13 December 2022

Our Ref: 2022/762784

**SSD-26876801 - The New Forest High School (New educational establishment)**

REFER TO DRAWING 0221 FOR CONTINUATION

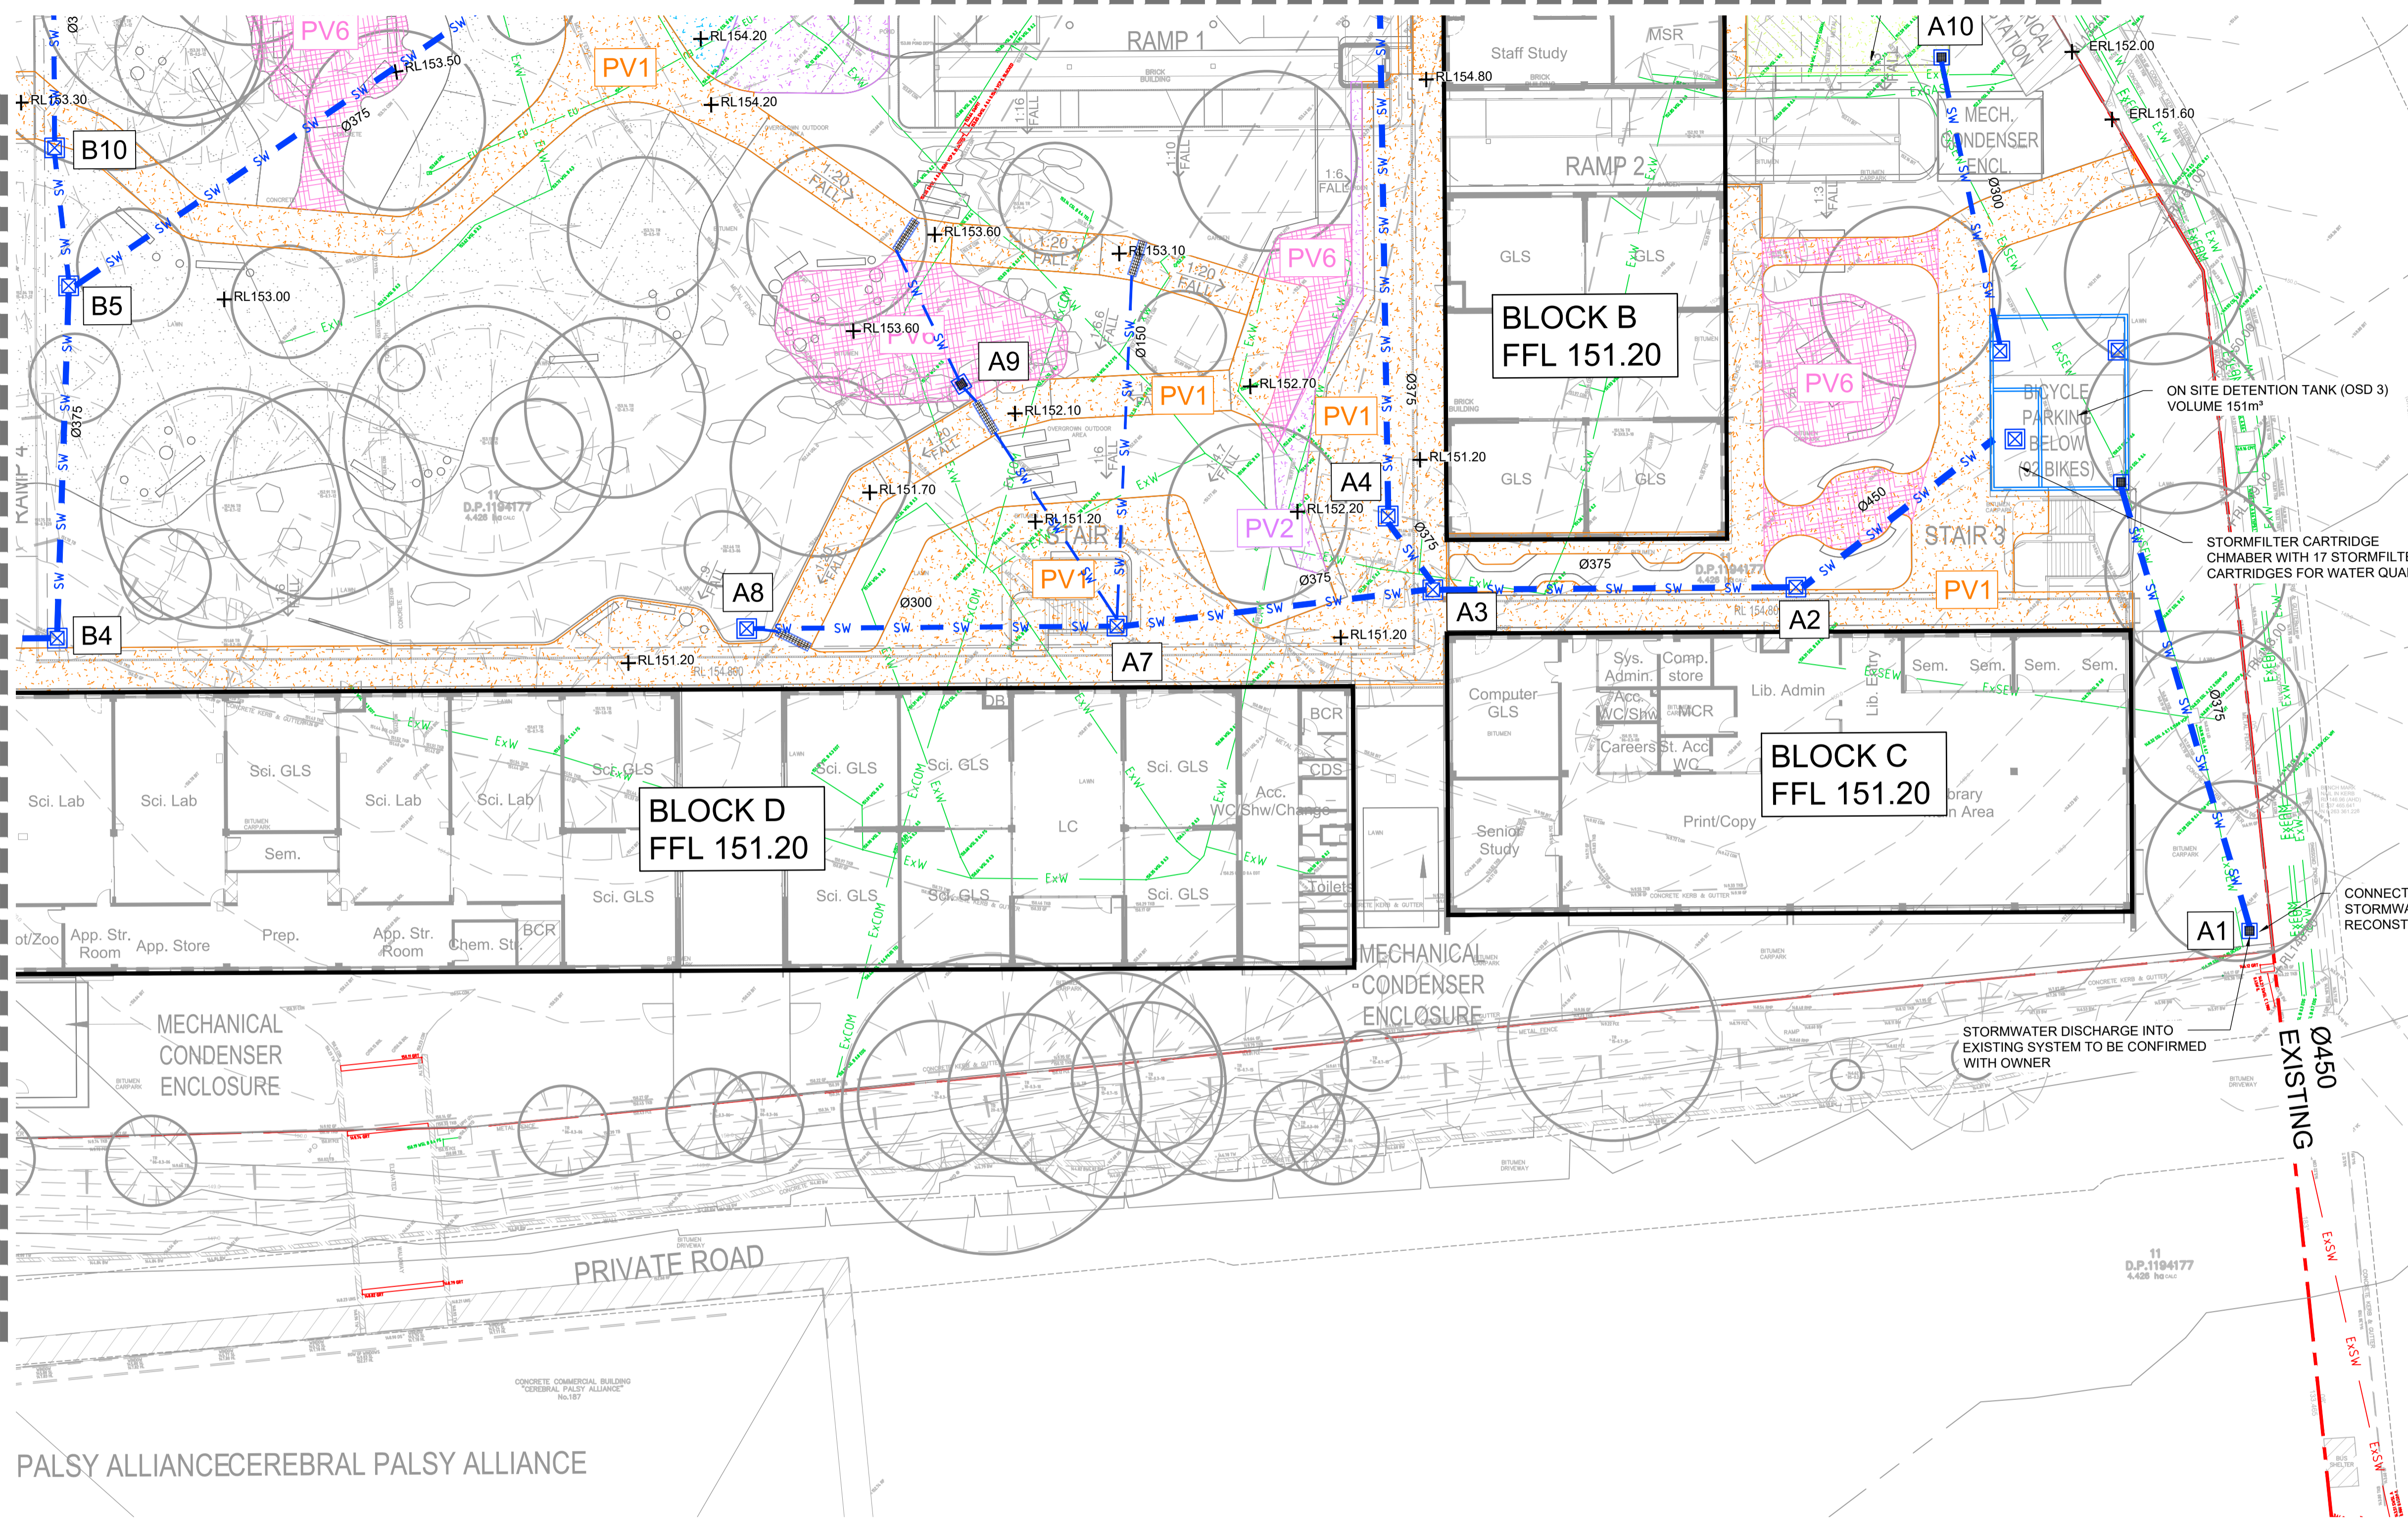
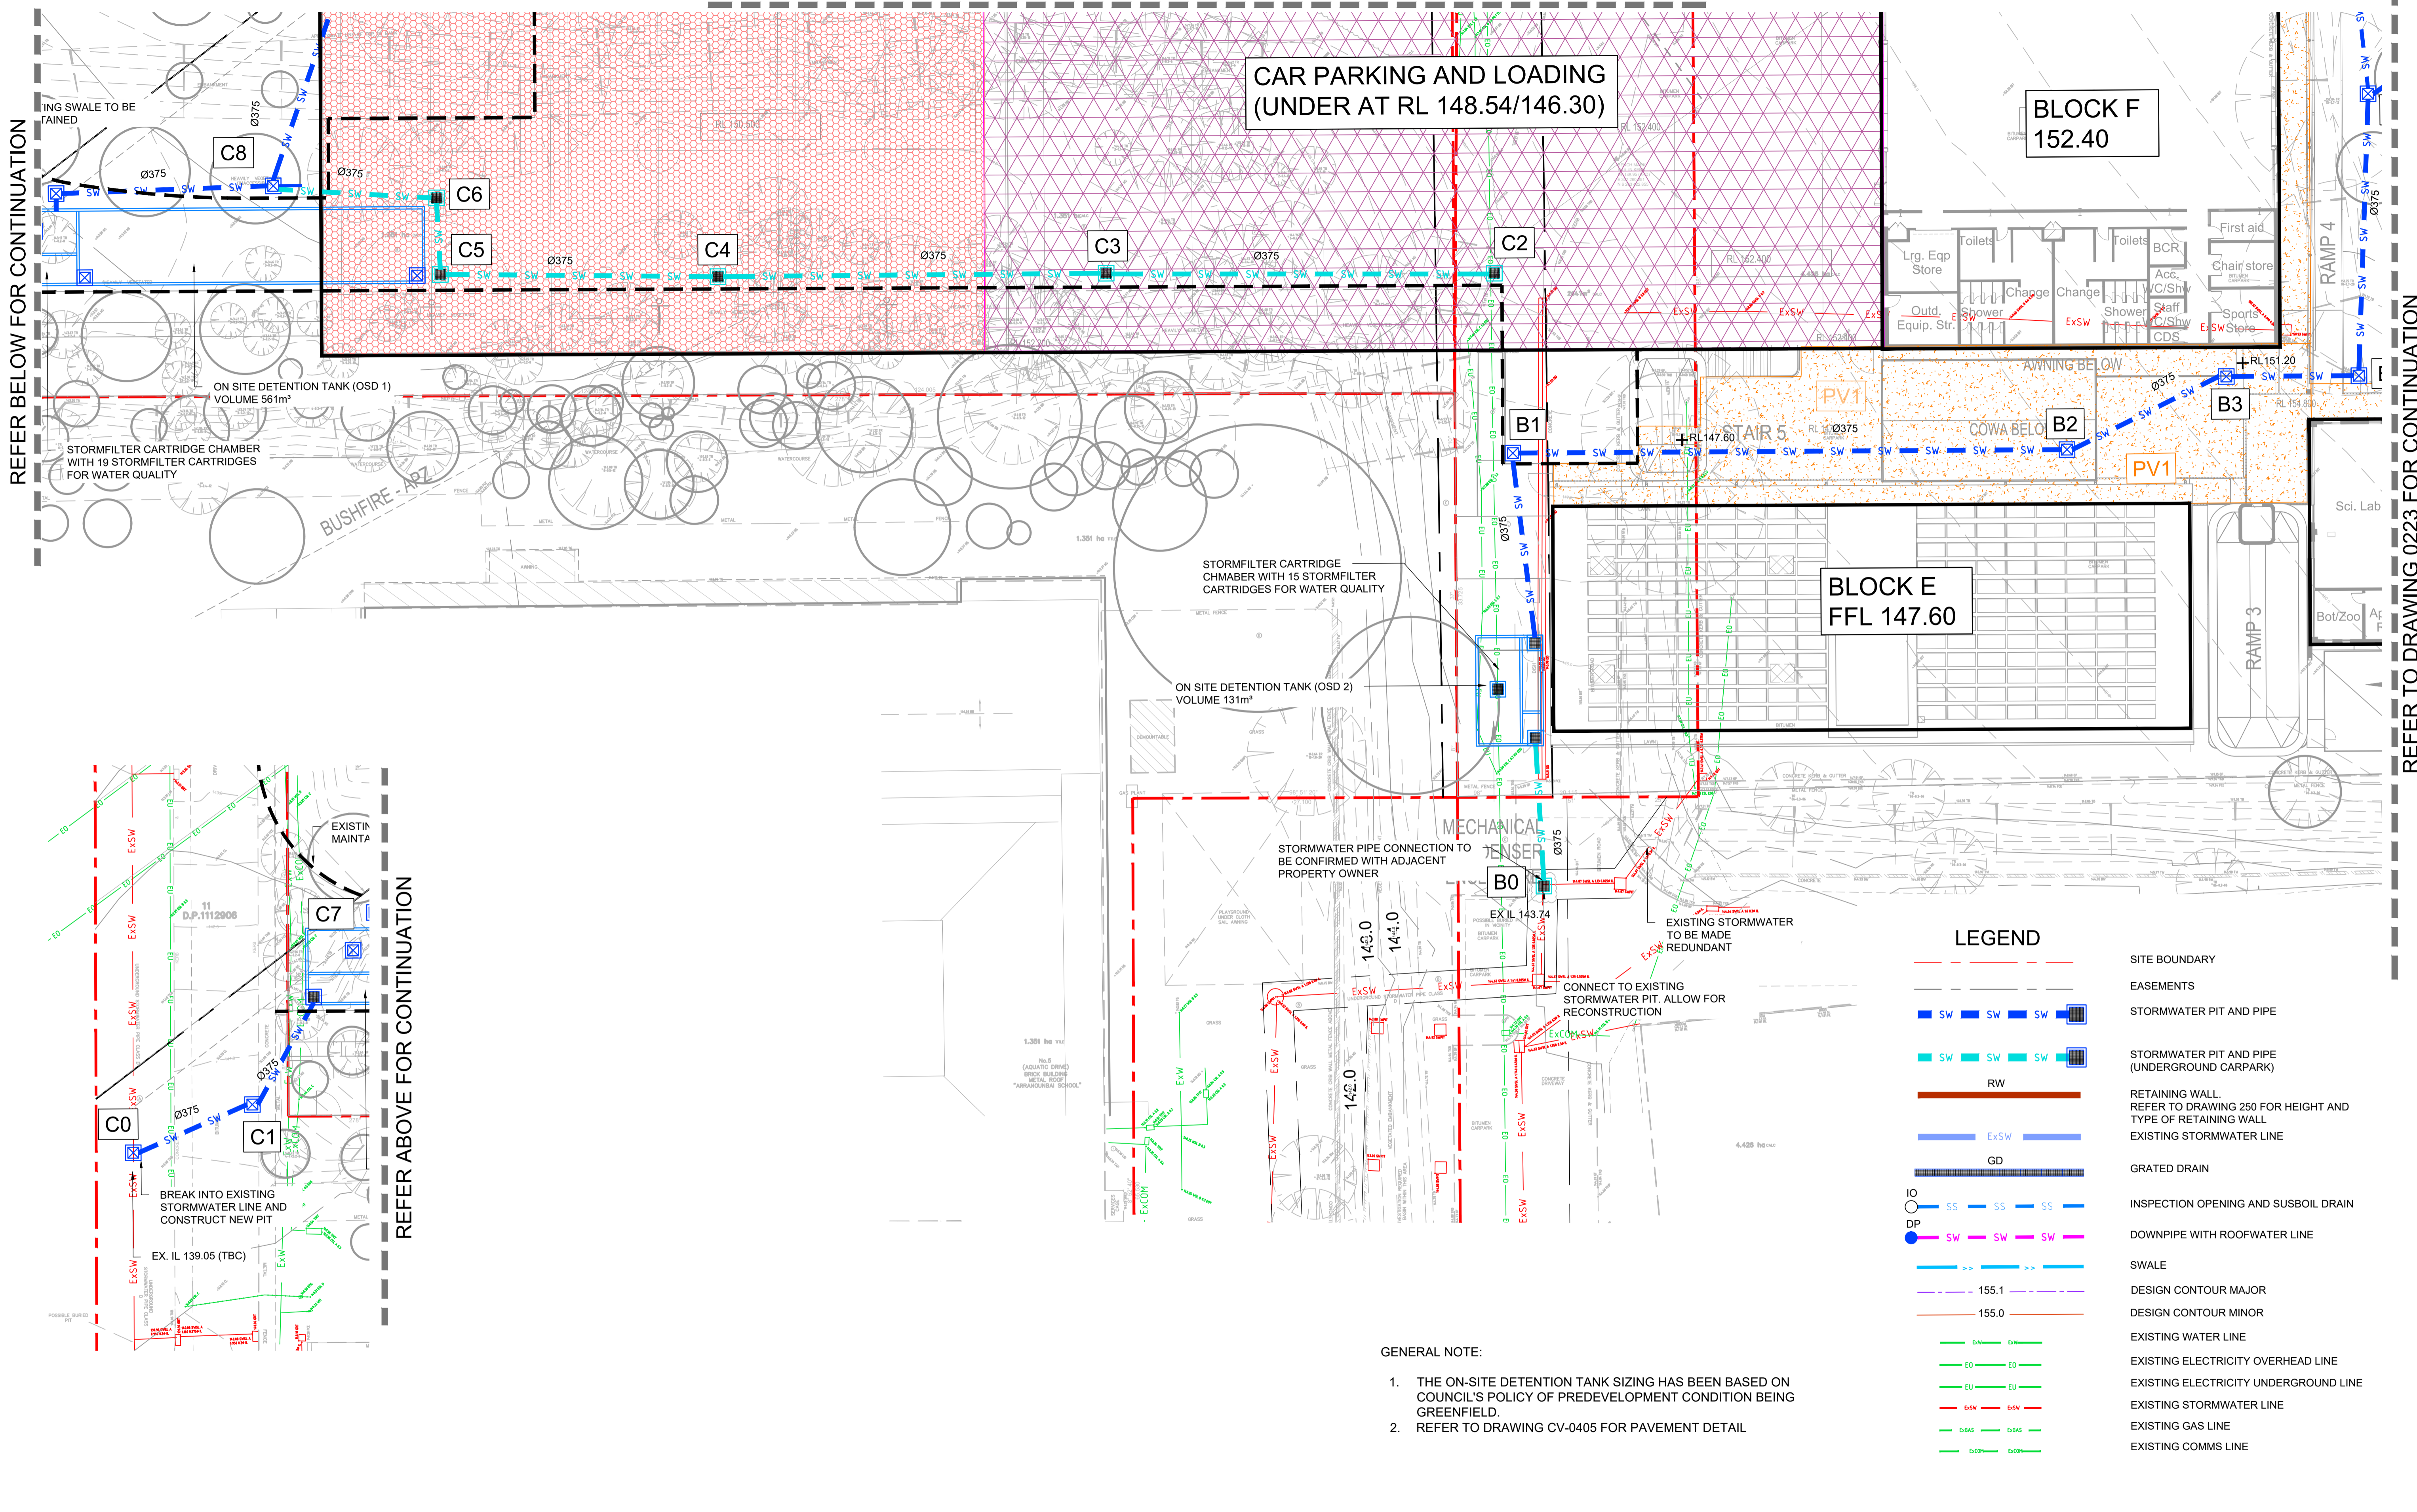
The stormwater drainage plans detail the extension of councils existing pit and pipe system from aquatic Drive with a 600mm RCP line. There appears to be a conflict with the extension of this line with a site drainage line which will runs over this line. The engineering consultant is to confirm whether there is a conflict and adjust the internal stormwater line location to avoid any potential conflict.
